Memorandum

September 9, 2014

Subject: CUATRO Senior Apartments
DRT# 14-010

WALL SIGN FRONT ELEVATION

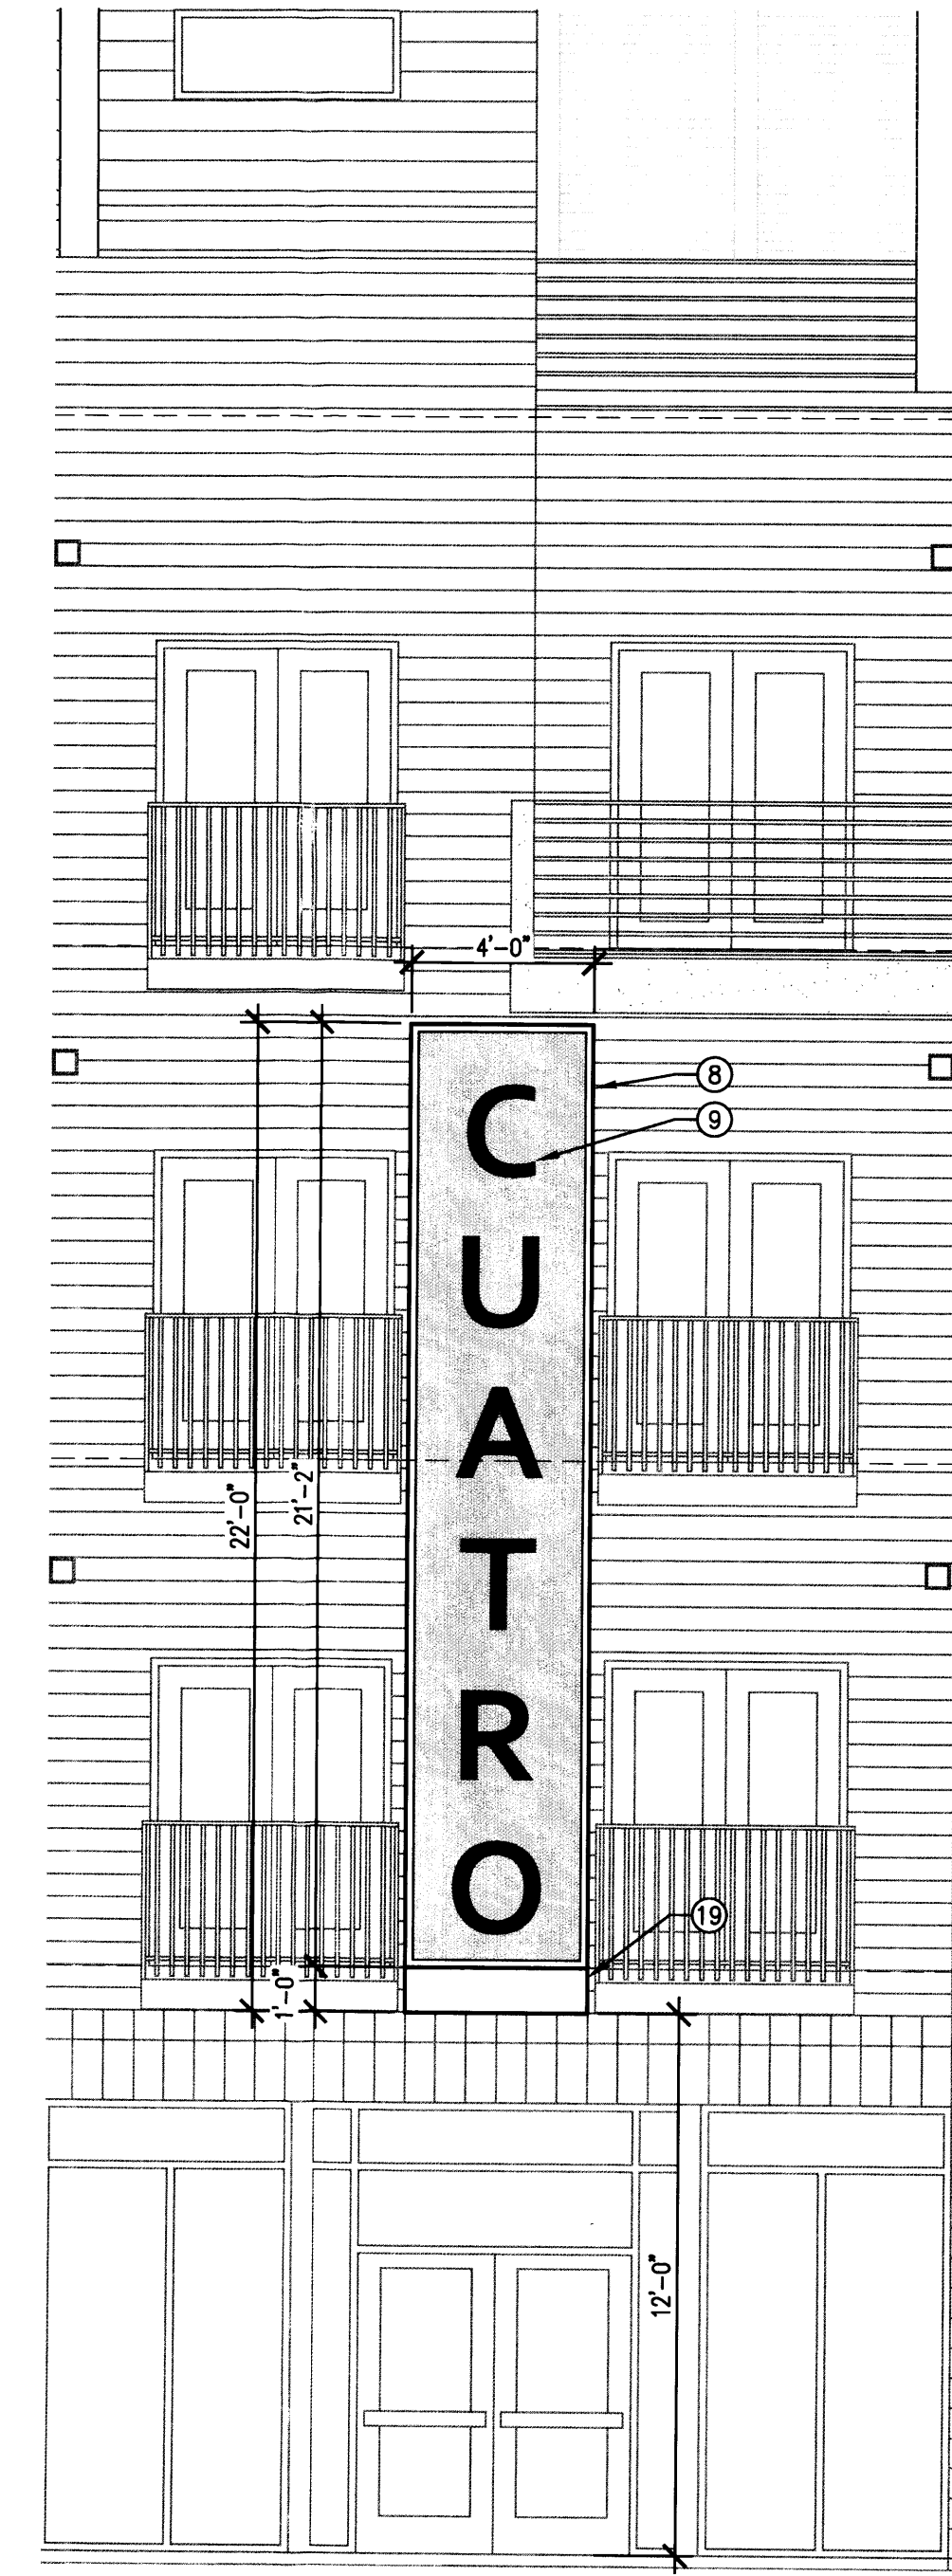
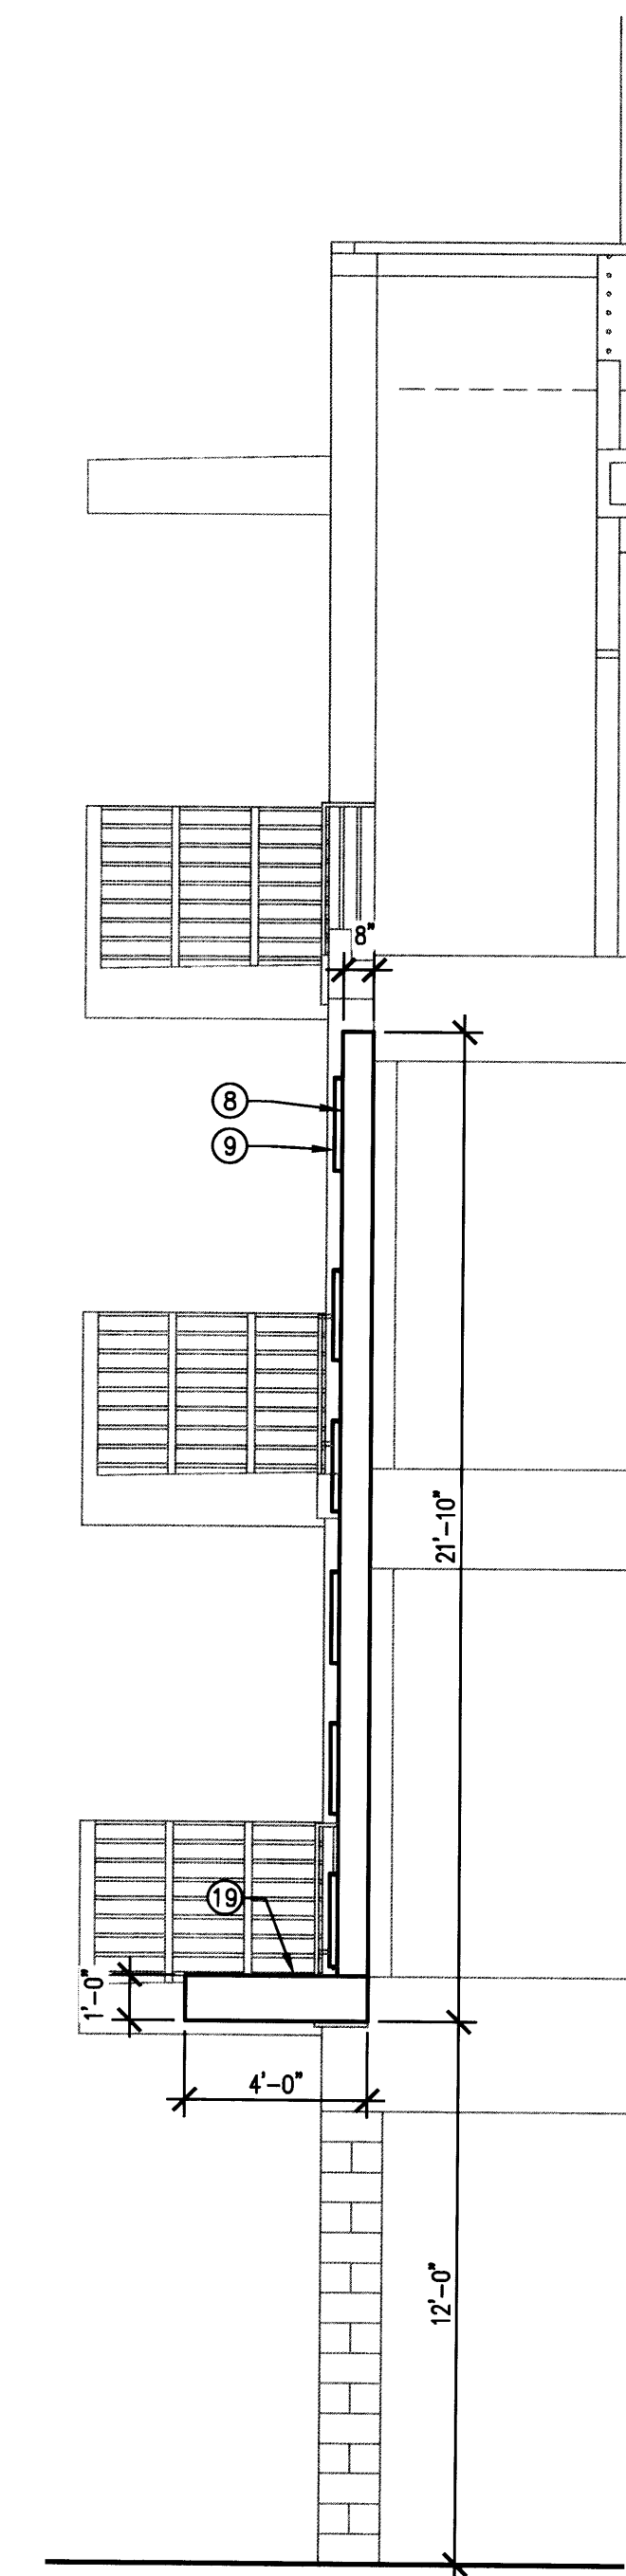
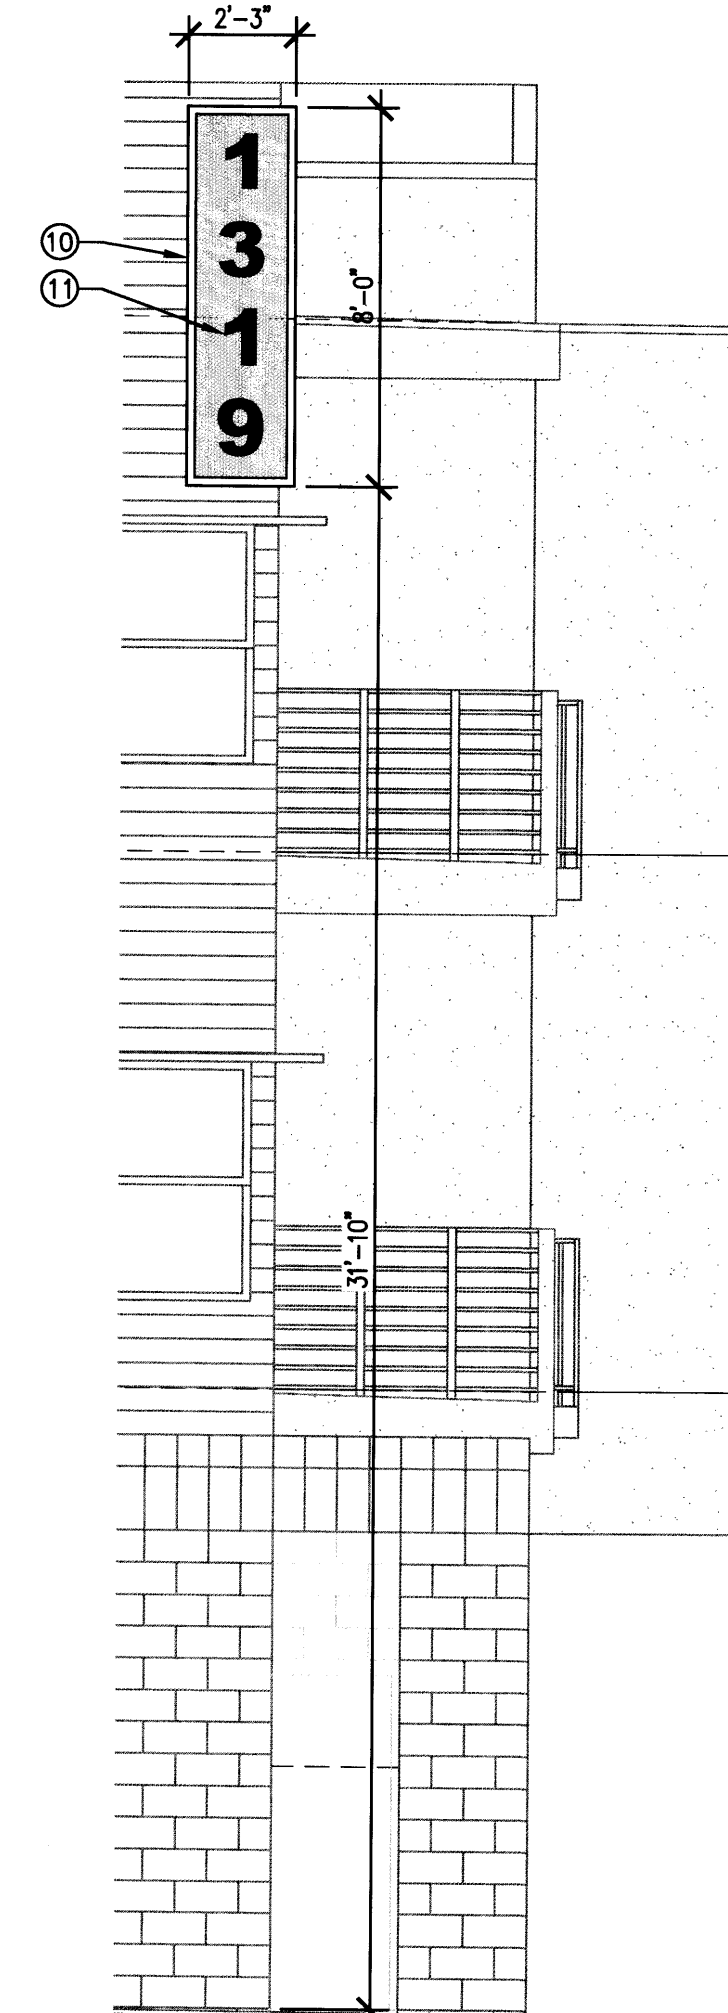
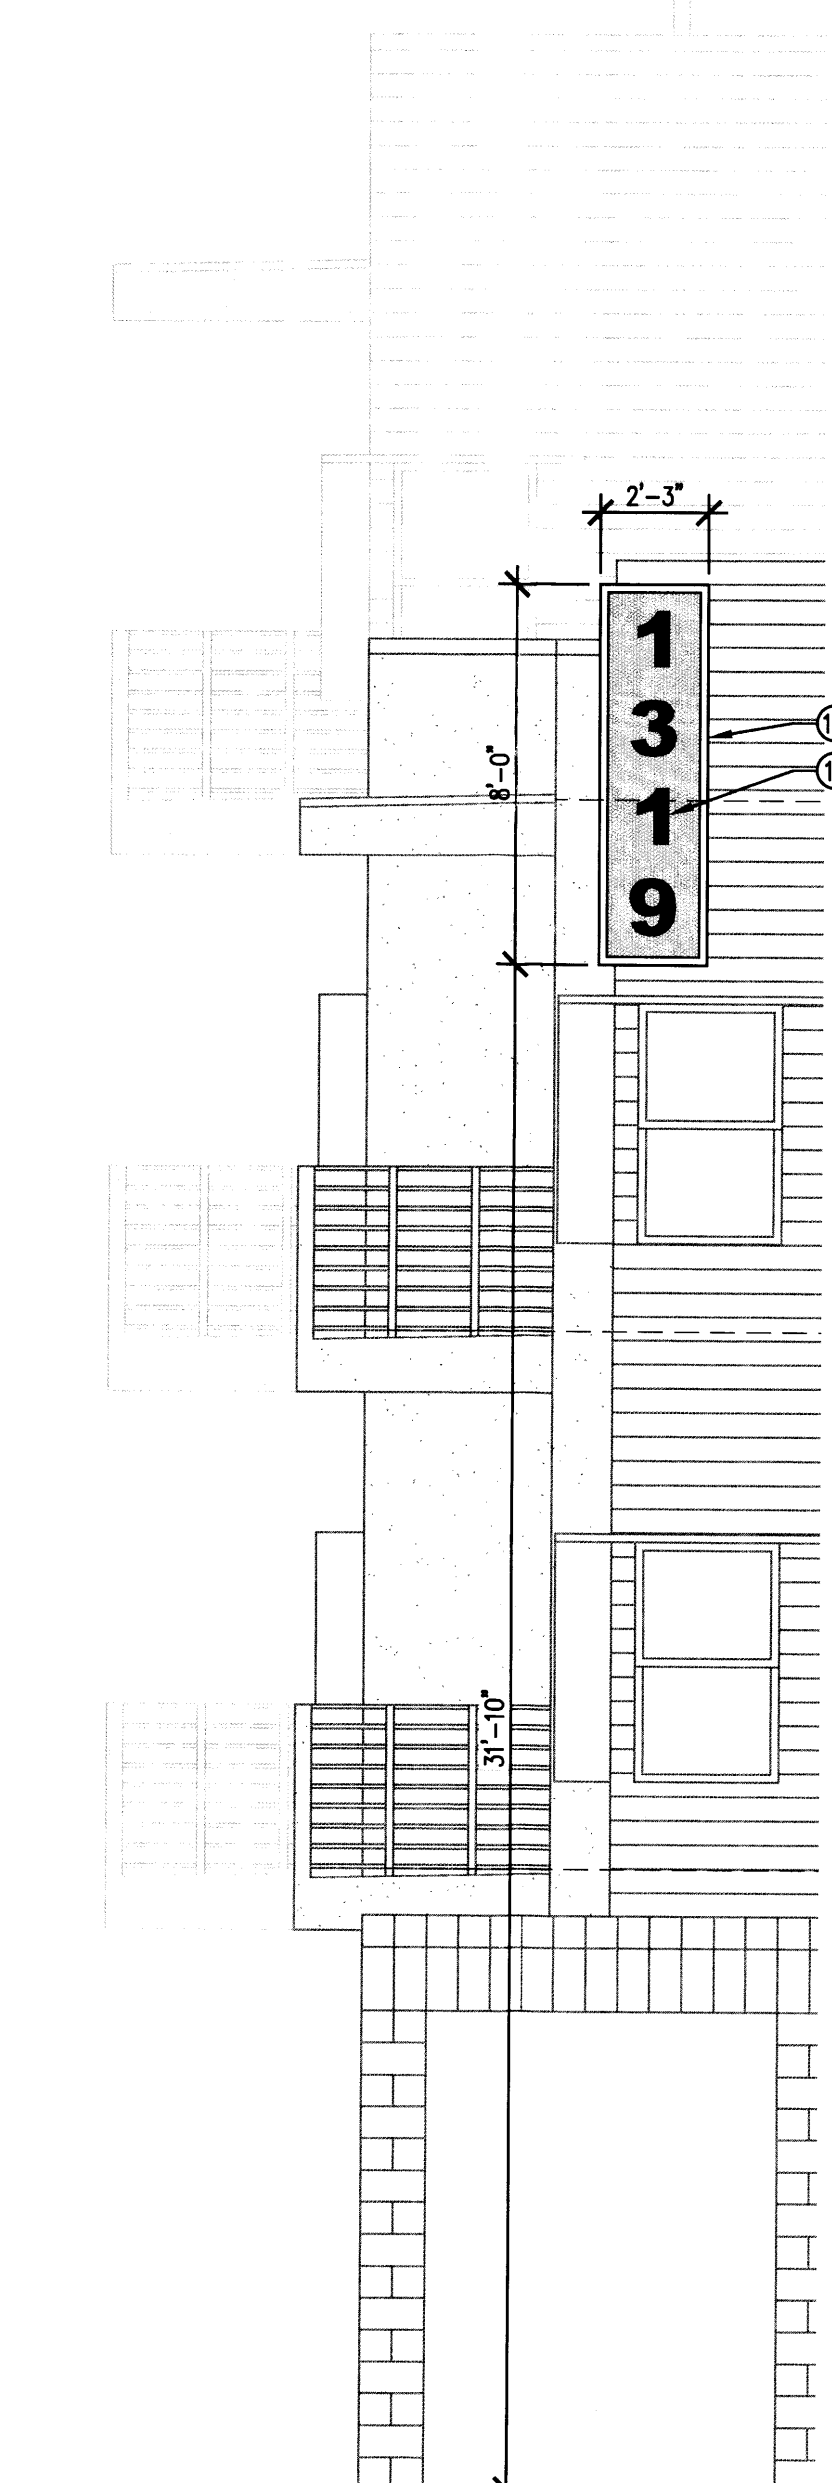
2. Building Mounted Signage

The Plan calls for the building mounted signage, including street addressing, to be placed between the second story line and the first floor ceiling and cannot exceed 2 feet in height. With the proposed building design, the allowable signage would be 2 feet in height and 300 feet long totaling 600 square feet (sf). The sign would have to be located 10 feet above the ground floor, which is the area where the portal, which runs along the entire front façade, is to be located. There is also the potential obstruction of view by the proposed street trees. The applicant wants to place the sign in the middle of the building running vertical for better visibility, and also so it does not conflict with the location of the portal. The sign would be 4 feet wide and 22 feet long totaling 88 sf, and would be located at the highest portion of the building. The Plan requires that the street address signs be located in the same area, presenting the same conflicts. The applicant is proposing to place two 18 sf address number signs at either end of the building facing Fourth Street. The applicant had discussions with Eric Mendoza, with the City's Fire Marshall's Office, who indicated that their preference is to place the address numbers as high as possible on the building for clear visibility and reduce the possibility of obstructions. (Email – Exhibit B).

The exact location of the proposed signs is not in accordance with the Plan, but with the location of the portal, it makes it impossible to place the sign in the area outlined in the Plan. Additionally, the placement required by the Plan would create a potential obstruction by street trees, creating a unique situation that warrants a deviation to the building mounted sign locations. *Staff finds that the deviation to the building mounted sign location is in substantial compliance and meets the intent of the Plan.*
